Arun District Conservation Area Advisory Panel
c/o Civic Centre

16th June 2020

Application No: BR/93/20/PL
Site Address: Mordington Cottage 6 Mead Lane Bognor Regis PO21 1HR
Description of works: Change of Use from office (B1(a)) to 1 No. dwelling & the provision of new garden boundary wall to the South of property. This application affects the setting of a Listed Building & affects the character & appearance of the Upper Bognor road & Mead Lane Conservation Area.

PROPOSED SOUTH ELEVATION - showing garden walls (new & extg)

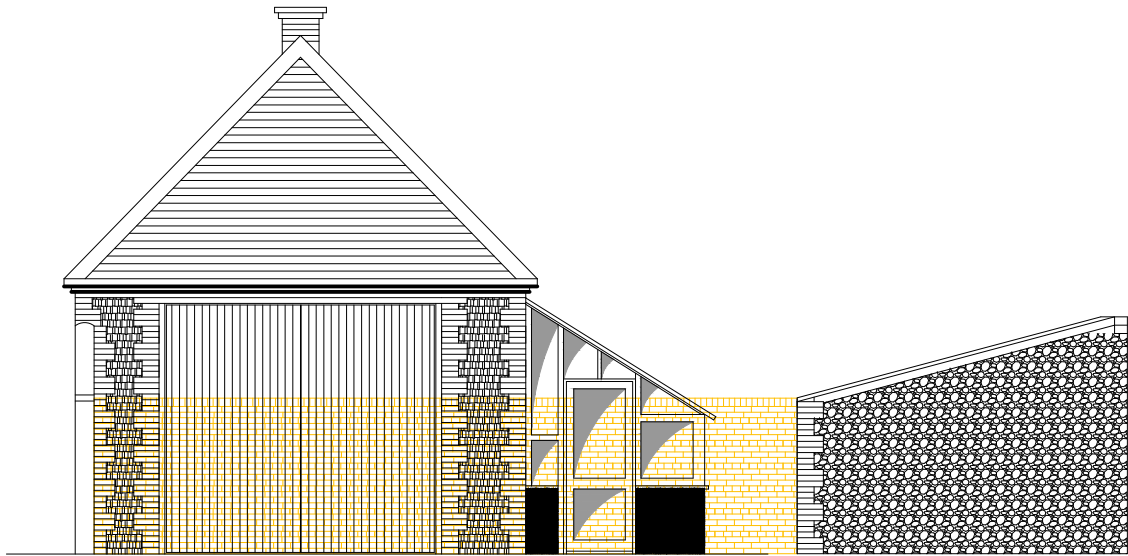
There is very little difference to the overall look of the building and the new rear walls appear to be appropriate in style and height.

It is noted that the opening to the "driveway" is currently obscured by a double, dilapidated, full length fence - heavily overgrown with ivy at its' northern end and the pedestrian gate at the other end of the property requires replacement as it is also in a very dilapidated state.. There is no driveway gate shown on the plans, but should one be envisaged, consideration should be given to matching the gates in an appropriate style and to match the style of the property and the front door which also requires attention. These details, together with some good husbandry of the wall shrubs would maintain the overall look and semi-rural style of this part of the Conservation Area.
